**APPLICATION BY HIGHWAYS ENGLAND FOR AN ORDER GRANTING DEVELOPMENT
CONSENT FOR THE A14 HUNTINGDON TO CAMBRIDGE IMPROVEMENT SCHEME**

WRITTEN REPRESENTATIONS FROM THE UNIVERSITY OF CAMBRIDGE - DEADLINE 2

The Written Representations from The University of Cambridge to the drawings issued by The Planning Inspectorate to support Highways England’s application for an Order Granting Development Consent for the A14 Huntingdon – Cambridge Improvement Scheme

Deadline 2 – June 12th, 2015

**FLOOD COMPENSATION AREA
(FCA 22) SECTION 22A - 22A
WORKS PLANS SHEET NO. 20**

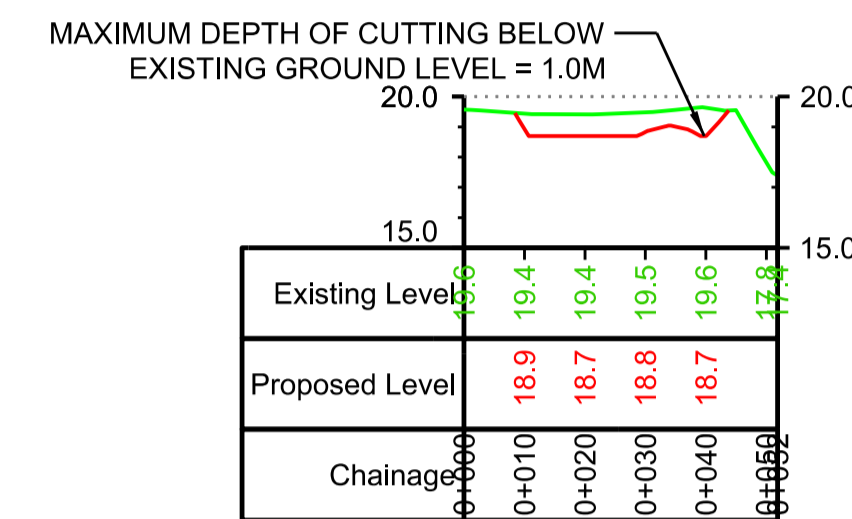
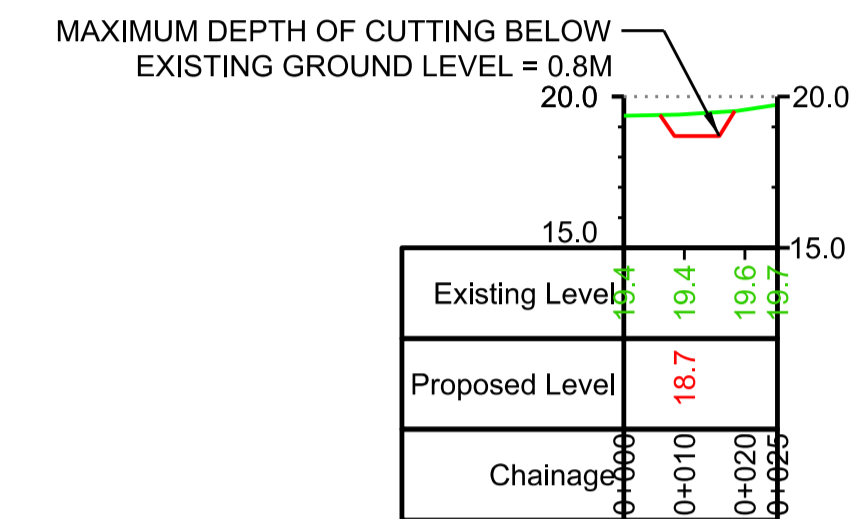
Catch Hall Farm, Girton	<ul style="list-style-type: none"> - A significant-sized floodplain compensation area is proposed to the south of Catch Hall Farm. This pond is to stay within the ownership of the University. 	<ul style="list-style-type: none"> - Further details are sought by the University regarding the likely use of this land, any future management requirements or operational restrictions, and whether it is allocated for temporary use during construction or permanent use.
